Our ref: HA/2009/106757/04-L01
Your ref: A/158/08
Date: 10 September 2009

**ERECTION OF 11 DWELLINGS WITH REAR PARKING COURT & ASSOCIATED
LANDSCAPING - GROUNDWATER MONITORING RESULTS STATION ROAD
ANGMERING**

Thank you for forwarding the "Second Interim Completion report " Ref: MAS-BH-313-1 dated 21 August for the above site. We have the following comments to make:

Figure 16: Approximate Locations of Free Phase Removal Sumps

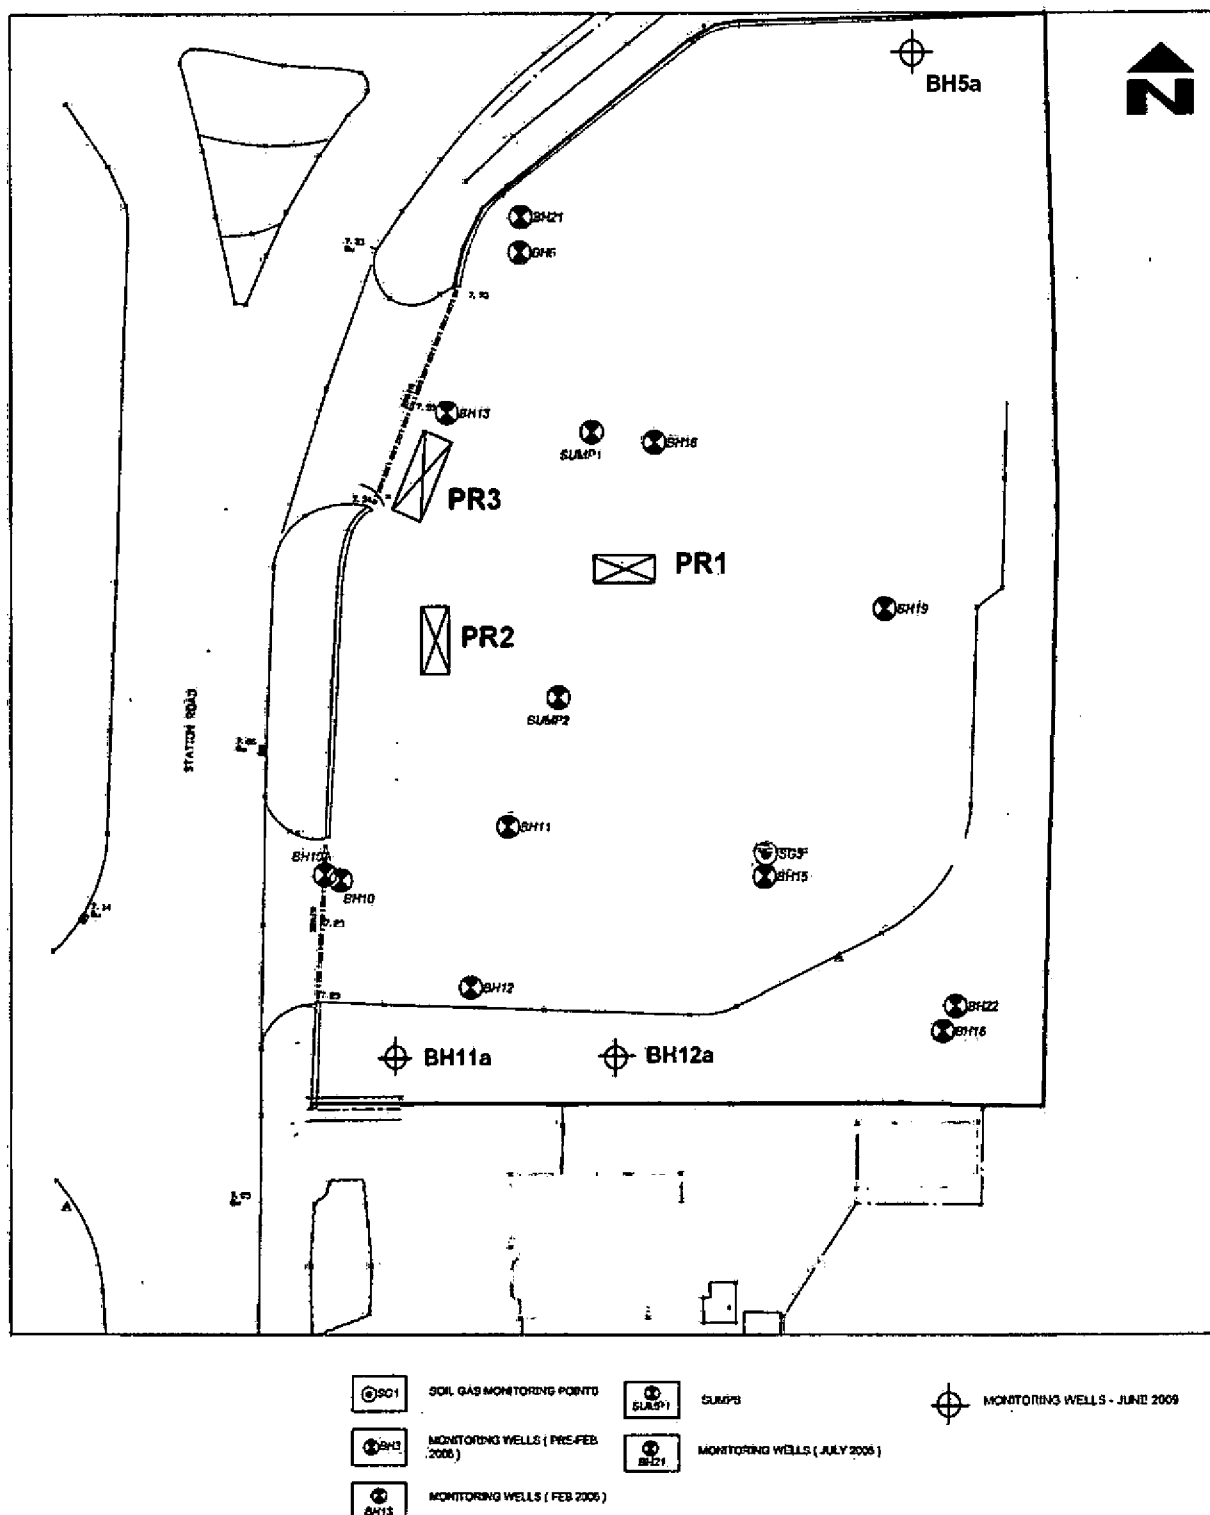
SLR301 - 26 mg/l Total TPH
PR1 - 44 mg/l total TPH (down from 63 mg/l in June 2008)
PR2 - 7.8 mg/l Total TPH (down from 8.4 in June 2009)
PR3 - 8.3 mg/l Total TPH (down from 16 mg/l in June 2008)

We would encourage continued monitoring of the existing boreholes and observation for any free phase product and removal if identified within the sumps PR1 - 3.
